COMMUNITY DEVELOPMENT DEPARTMENT
501 Delta Avenue ♦ Marysville, WA 98270 ♦ (360) 363-8000

September 1, 2023

Re: M-51 Industrial – *Technical Review 1*
PA 23014

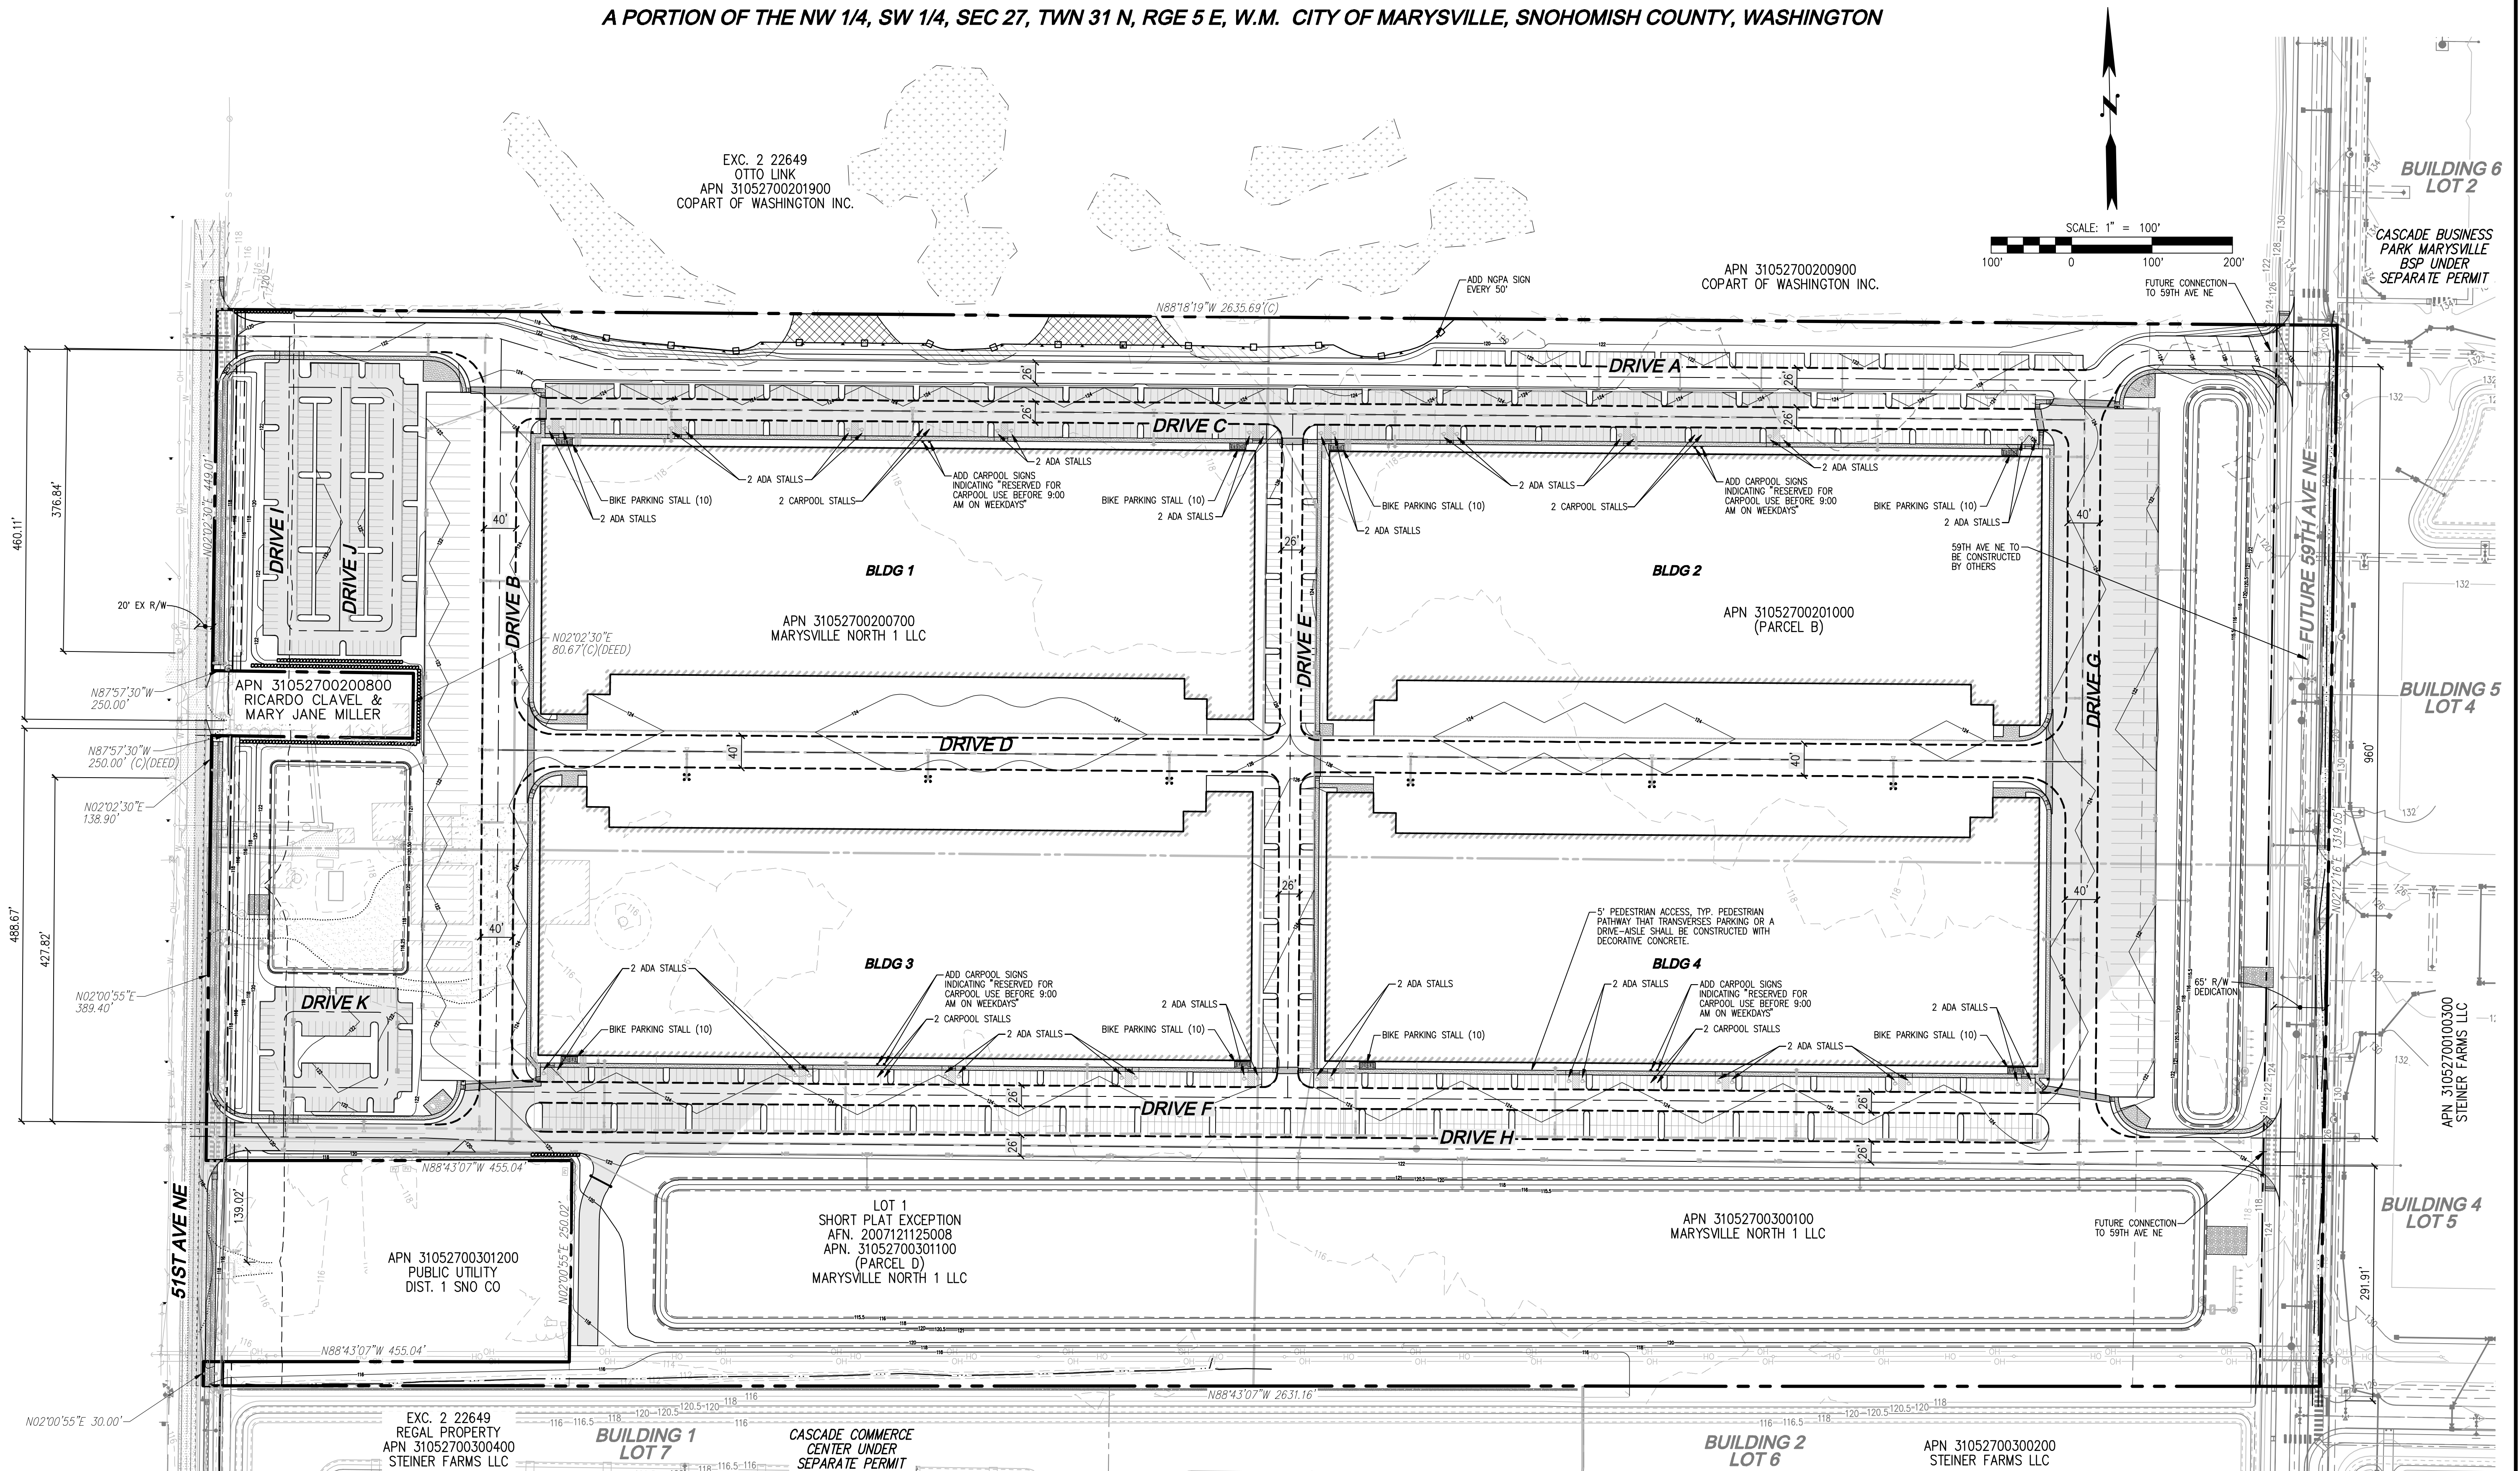
3. The site plan shall be amended, as follows:
 - a. Pedestrian connections shall be provided from 51st Avenue NE and 59th Avenue NE and the building entrances. Pedestrian pathways that traverse a parking area or drive-aisle shall be constructed with decorative concrete.

- b. Parking areas shall include a landscape island every 10 stalls. The landscape islands shall be a minimum of 5' in width and 120 SF in size.
 - c. The site plan states the drive-aisles measure 24' in width, however, they only measure 22' in width.

- d. The standard parking stalls shall measure 8.5' x 18'.
 - e. Provide off-street parking calculations, including standard ADA, carpool and bicycle demonstrating compliance with the MMC.

- f. Provide location of required ADA parking spaces.
 - g. Provide location of required carpool parking.
 - h. Provide location of required bicycle parking.

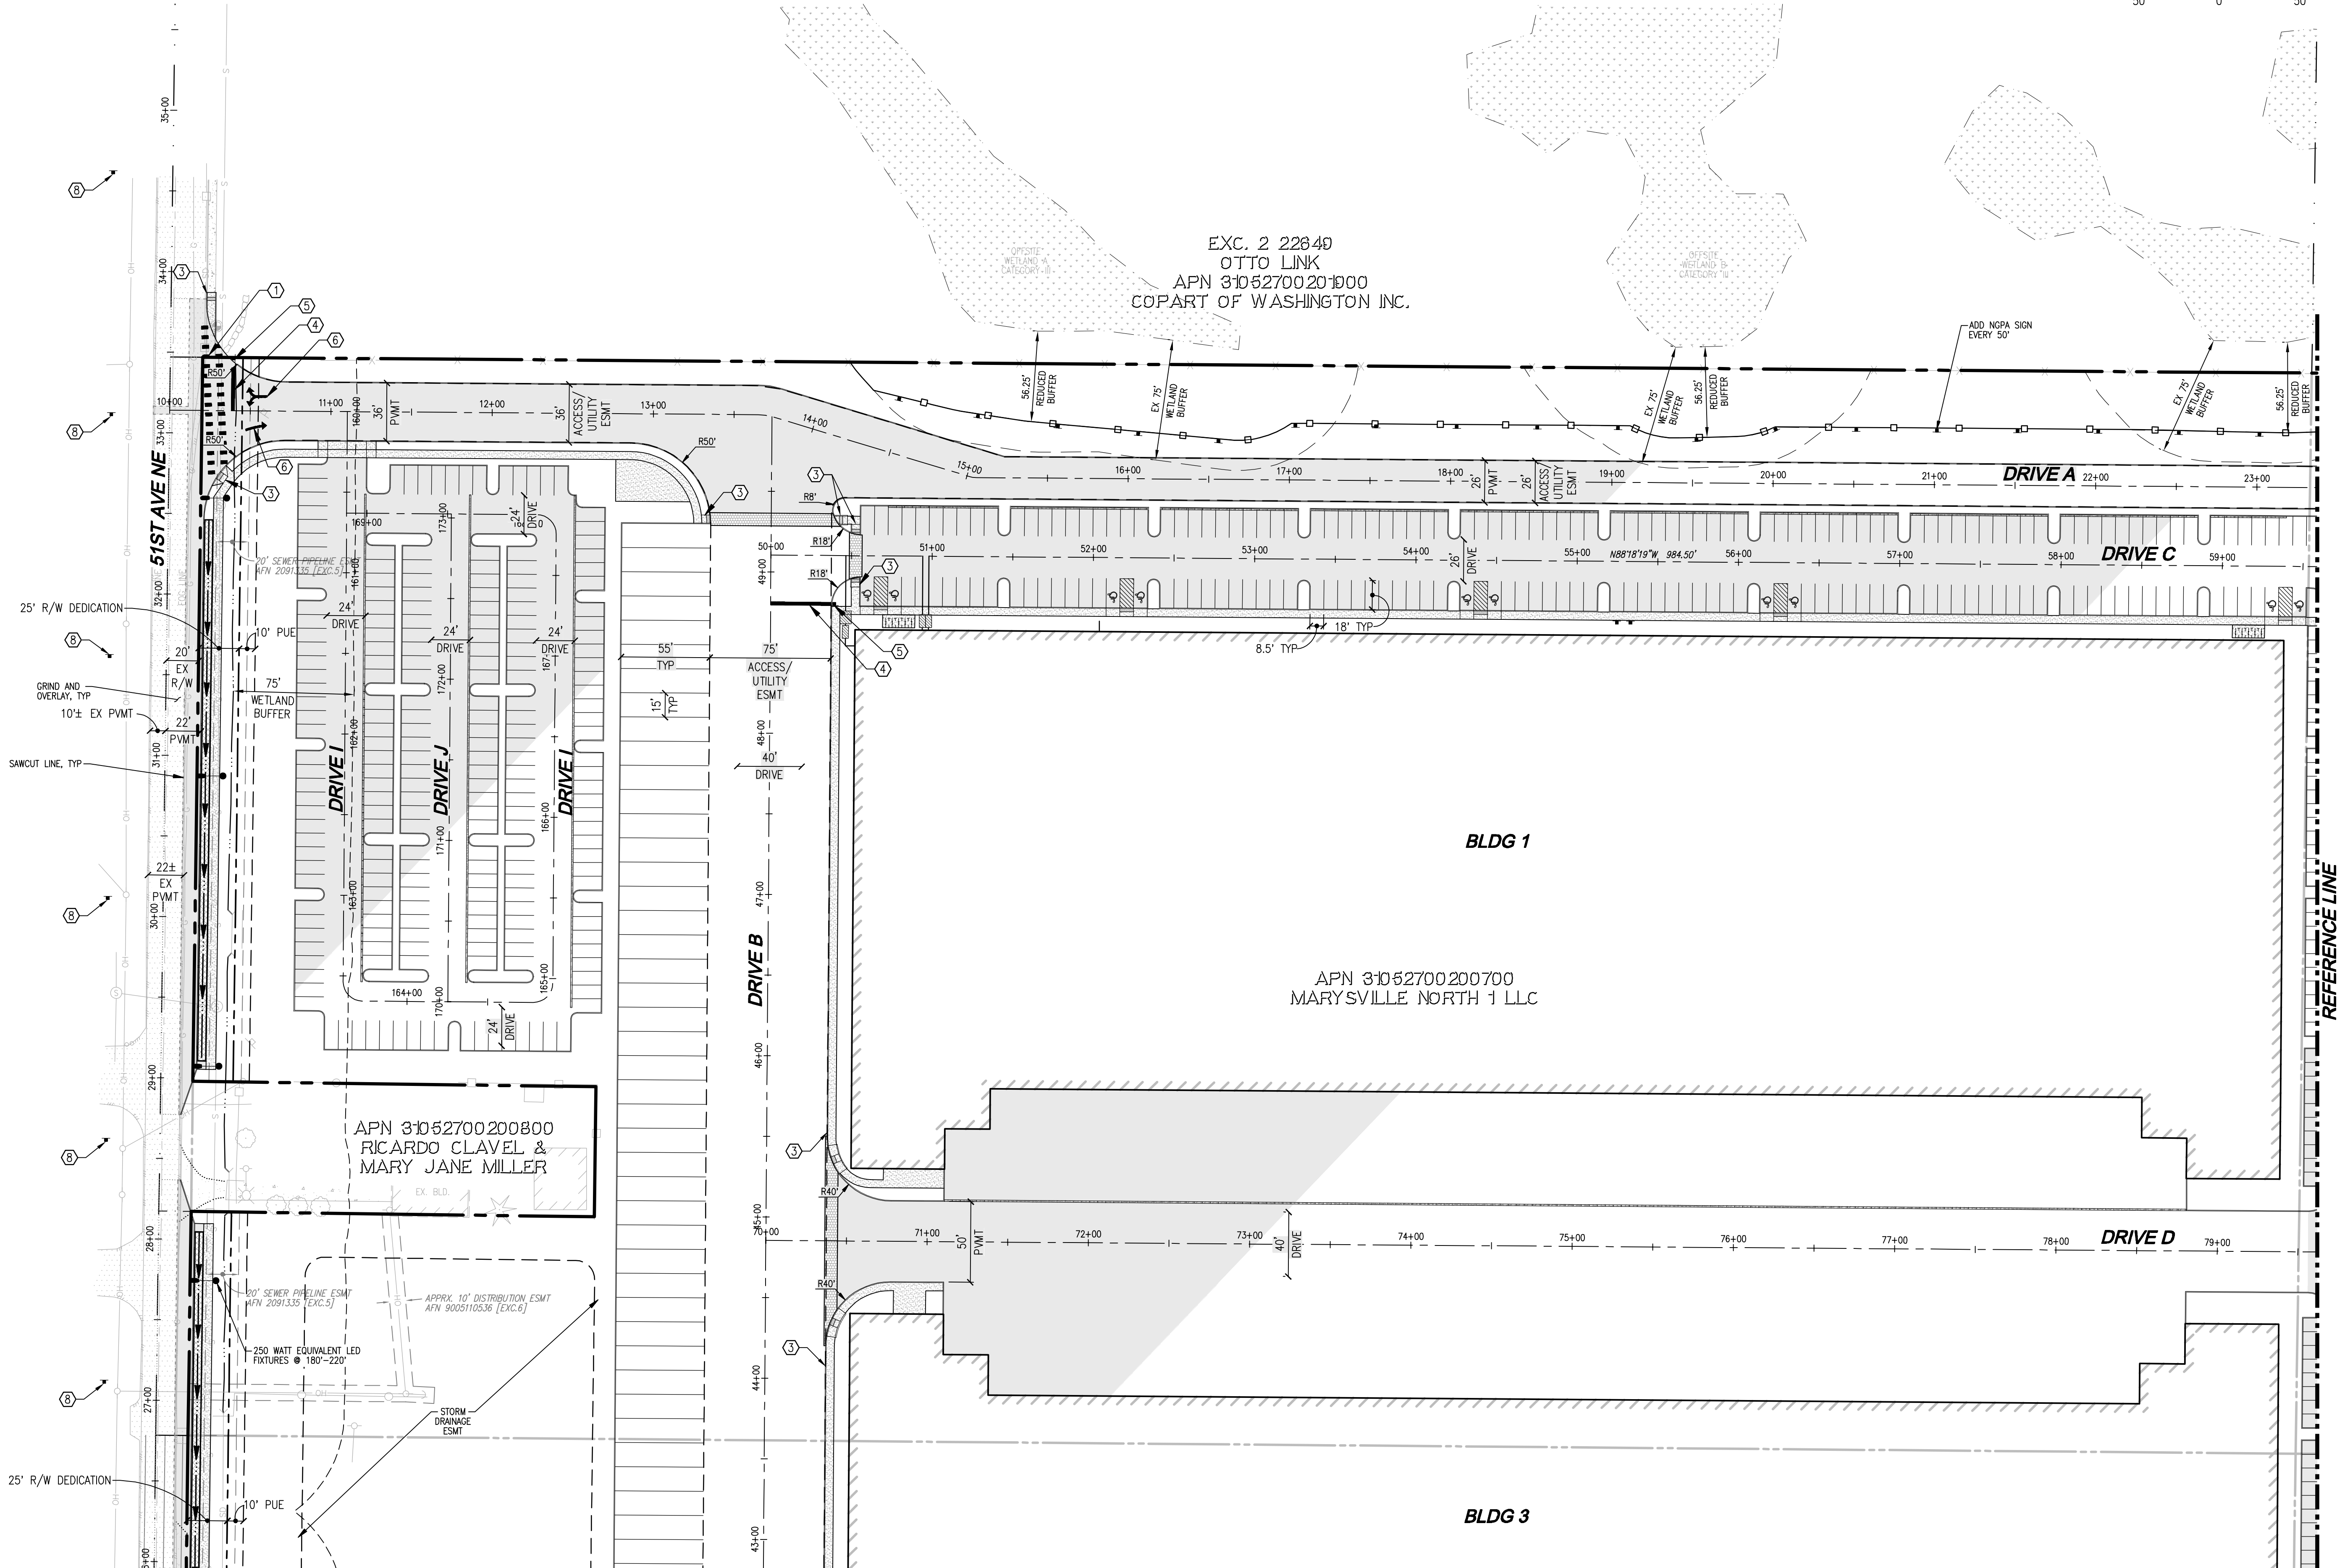
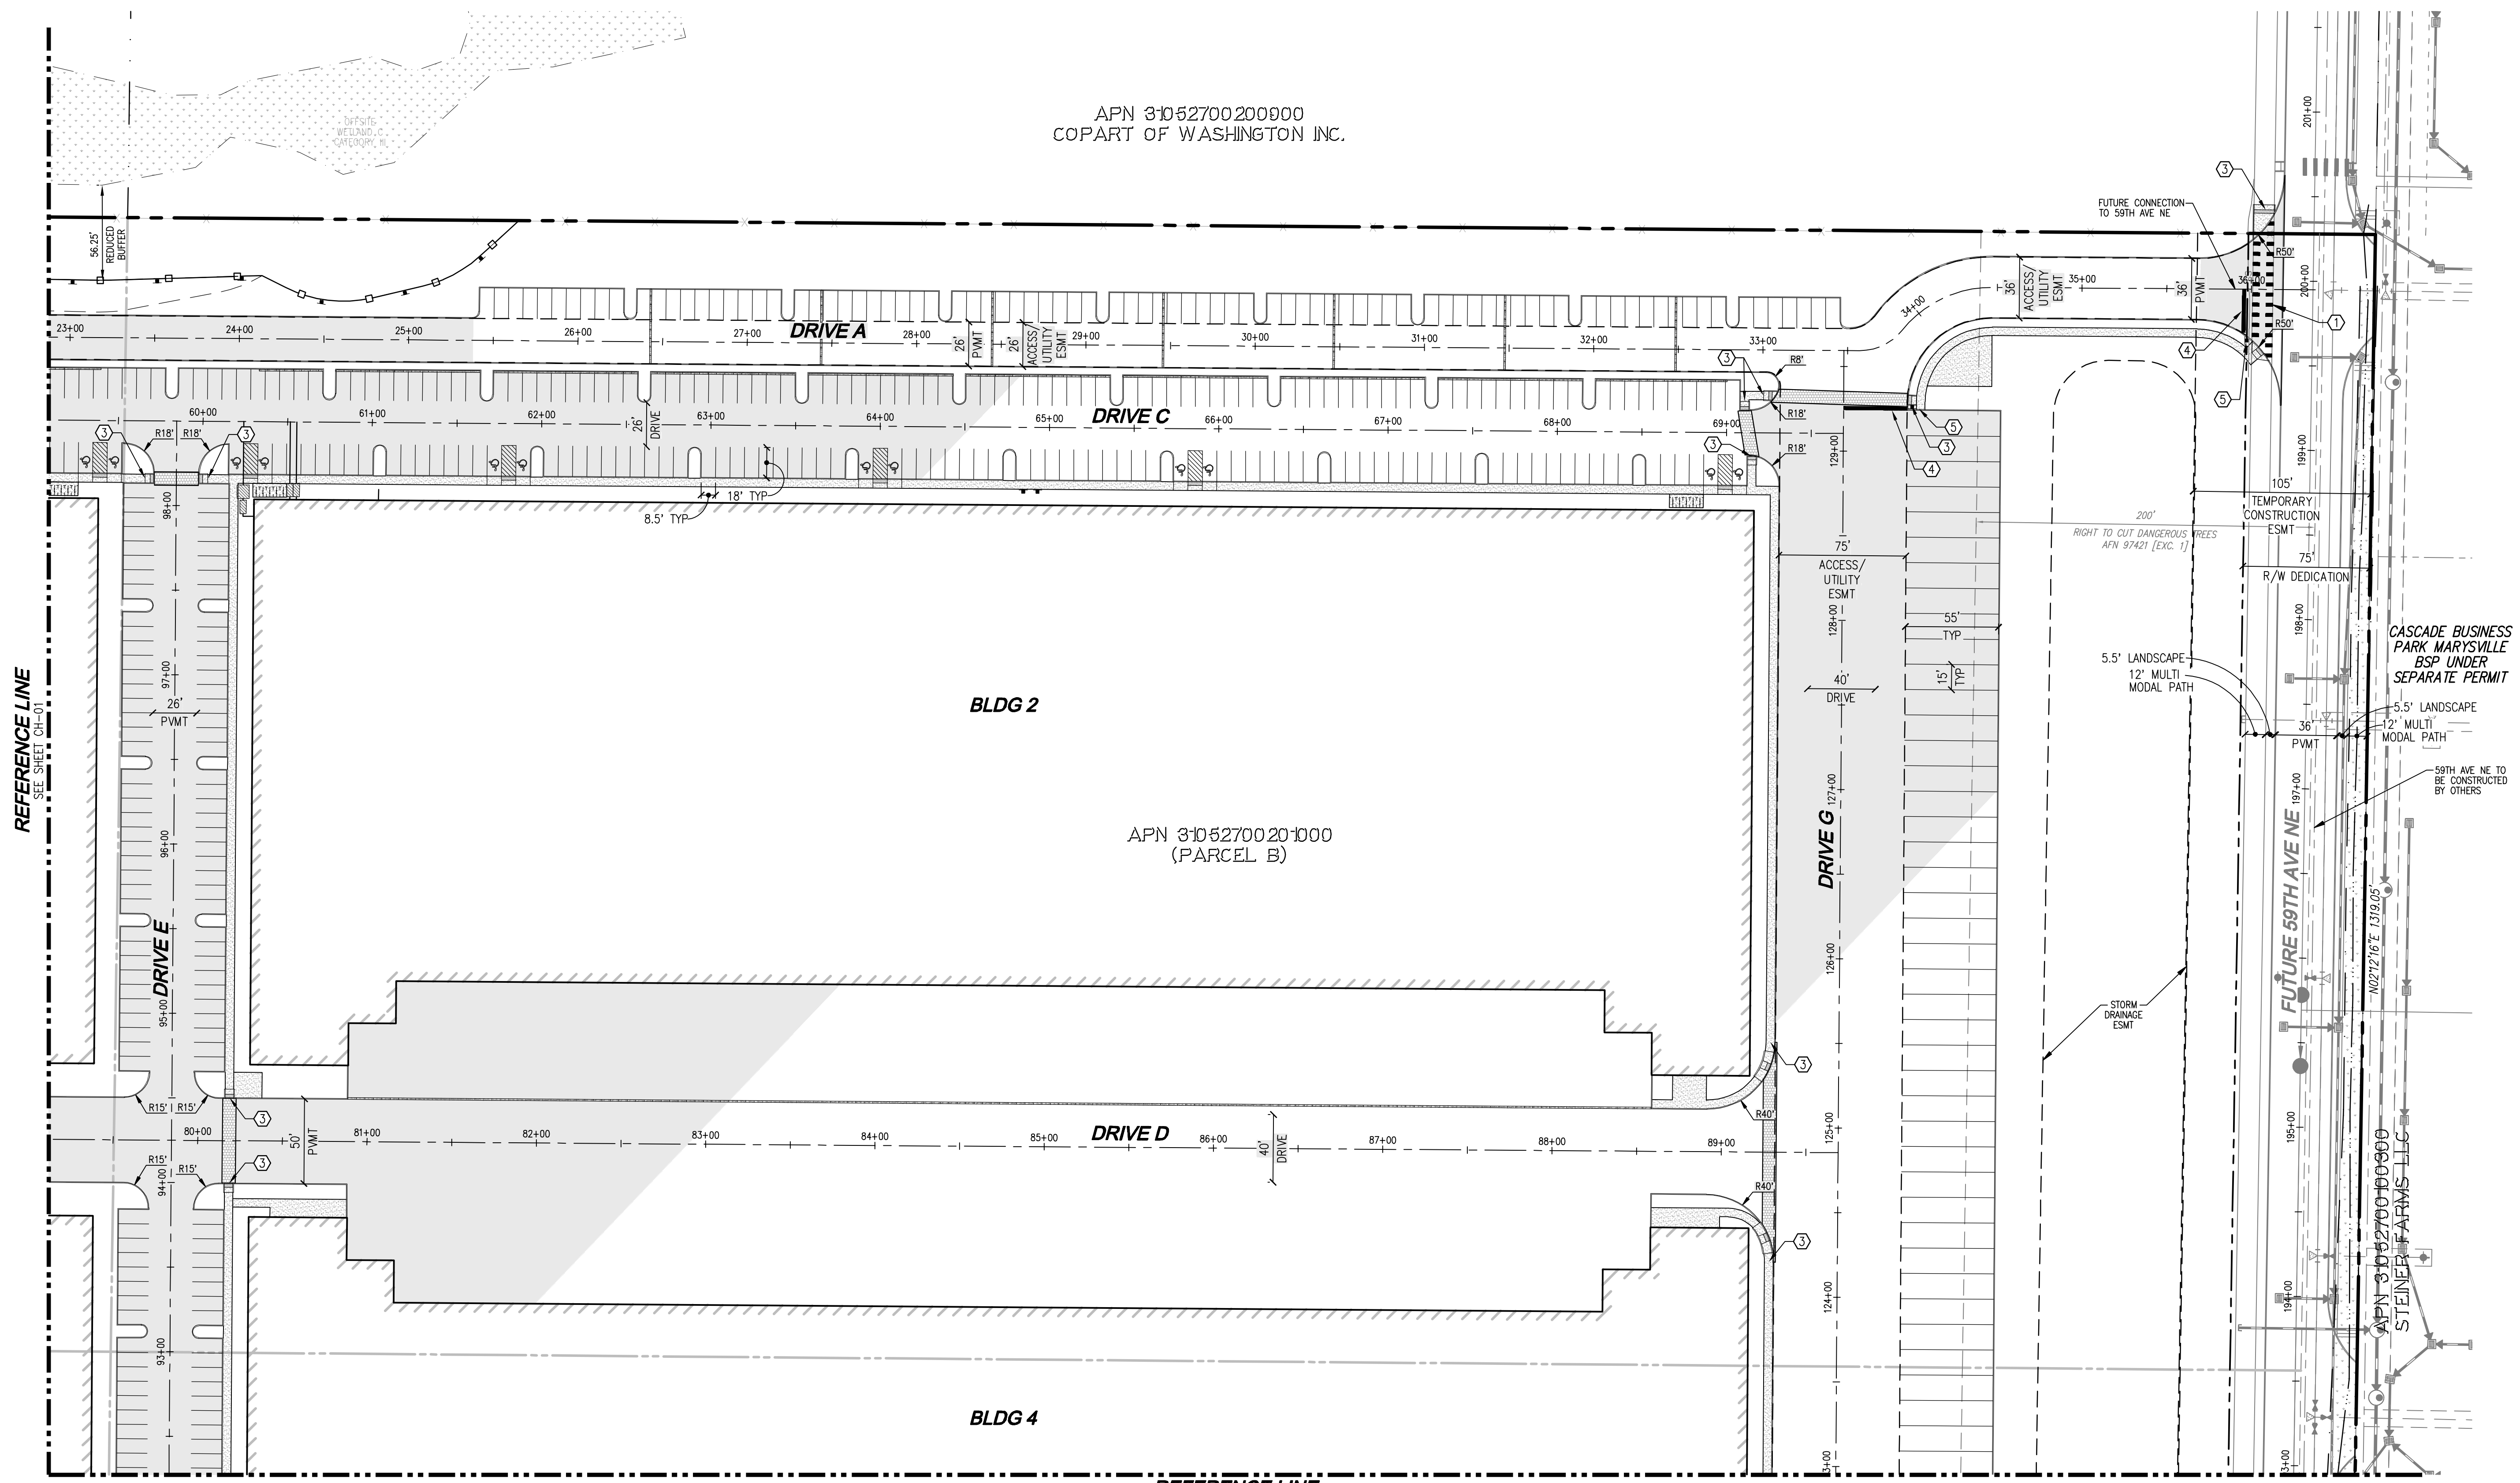
37. Per EDDS 3-506, street lighting will be required.
 - a. Street Lighting upon 51st Ave NE and 59th Ave NE shall be PUD installed fiberglass pole installation type street lighting.

- i. Street lighting shall be designed as minor arterial utilizing 250 watt equivalent LED fixtures.
 - ii. Spacing of fixtures should be approximately 180'-220'.

- iv. Contact Eddie Haugen of Snohomish County PUD at (425) 783-8276 or wehaugen@snopud.com for more information regarding PUD design.
38. Signing and Channelization Plans shall be required as part of Civil Construction plans.
